Planning Application Decision Notice

Application Number: 2025/62/91733/E

**ERECTION OF SINGLE STOREY REAR EXTENSION, ALTERATIONS TO
CONVERT GARAGE TO LIVING ACCOMMODATION AND ERECTION OF
DETACHED GARAGE**

At: 284, BARNSELY ROAD, FLOCKTON, HUDDERSFIELD, WF4 4AJ

title
Garage Plan & Elevations - As Proposed

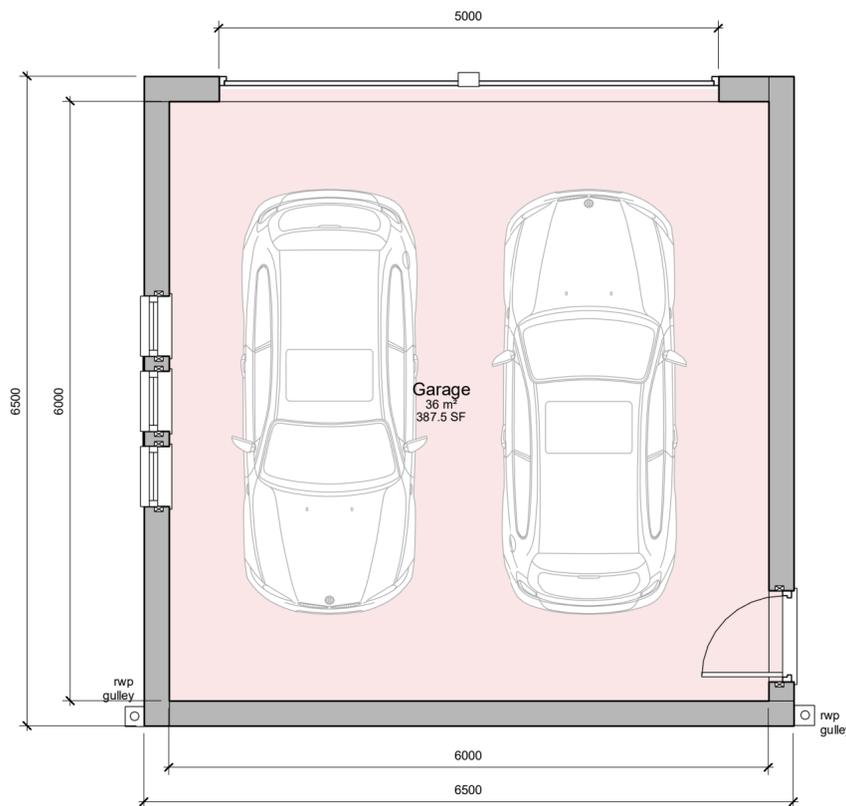
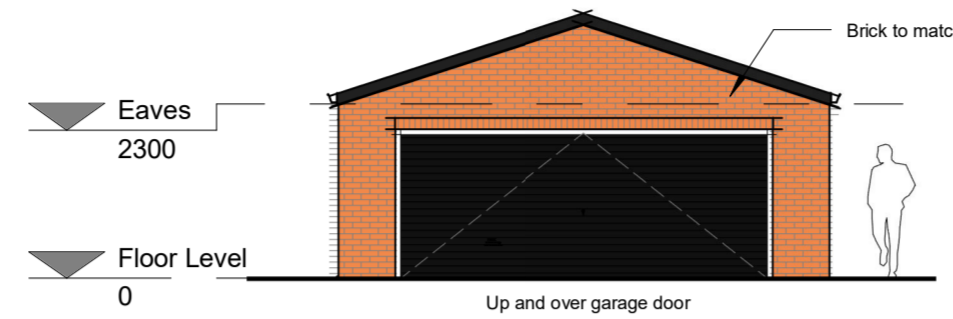
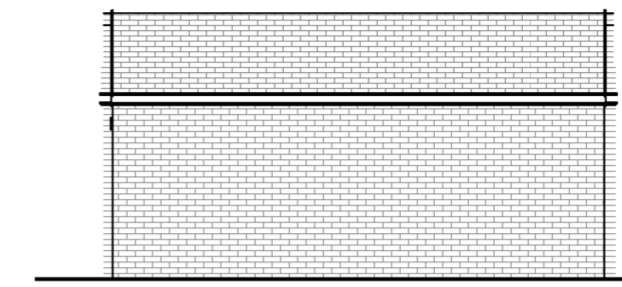
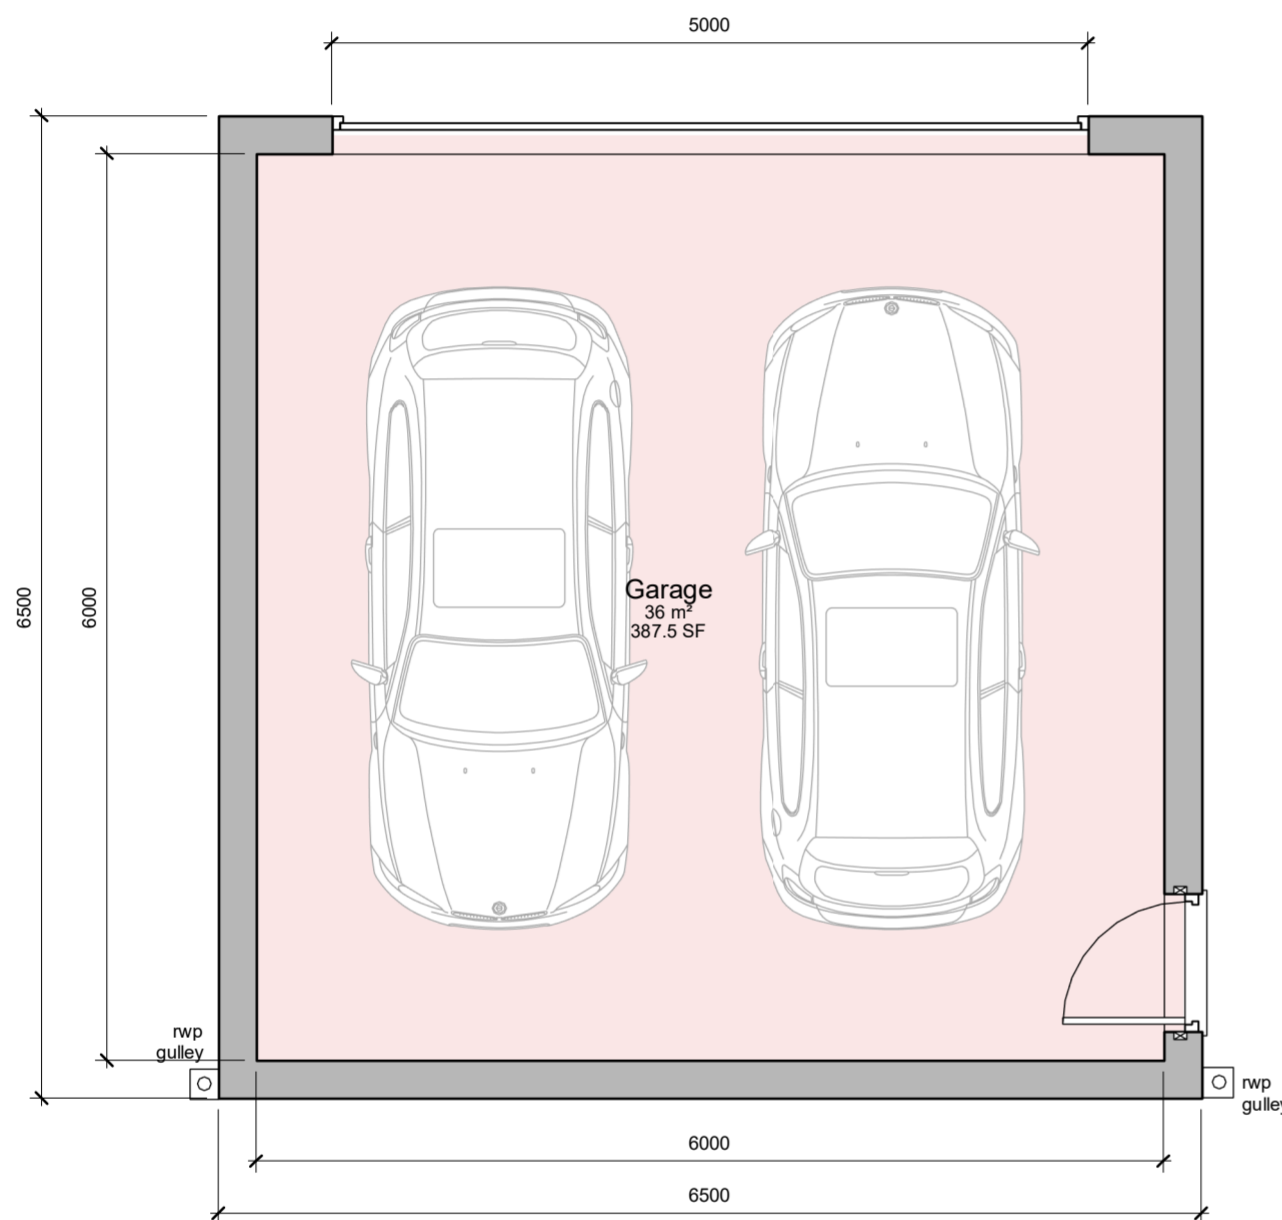
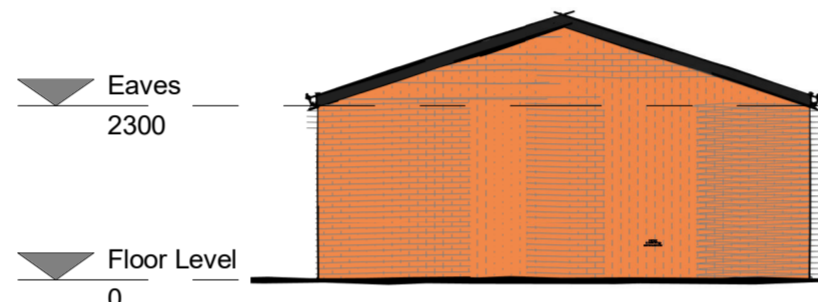
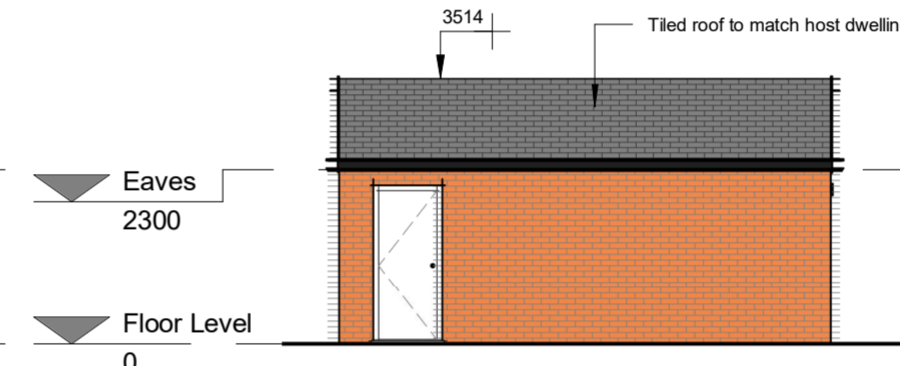
The applicant was requested to add design details on the proposed garage building due to the impact on the streetscene and location adjacent to the Green Belt/Agricultural fields. Amended plans were received changing the predominant material to stone with window openings on the north elevation. The changes were deemed suitable, introducing an active elevation facing onto Barnsley Road and to provide a material which is more suitable within the agricultural setting. The initial location plan area of development included the field to the south of the dwelling. Development does not include this land, therefore it was requested that the redline boundary was replotted to include land for development. An amended location plan & existing site plan was received. As the redline boundary was reduced, including land already identified for development it was not considered necessary to readvertise the proposal.

3. The external walls and roofing materials of the extensions and alterations hereby approved shall be built in accordance with illustration drawings A(10)-01 & A(10)-02 revA.
Reason: In the interests of visual amenity and in accordance with Policies LP01, LP02 & LP24 of the Kirklees Local Plan, Principles 1 and 2 the Council's adopted House Extensions and Alterations Supplementary Planning Document and policies within Chapter 12 of the National Planning Policy Framework.
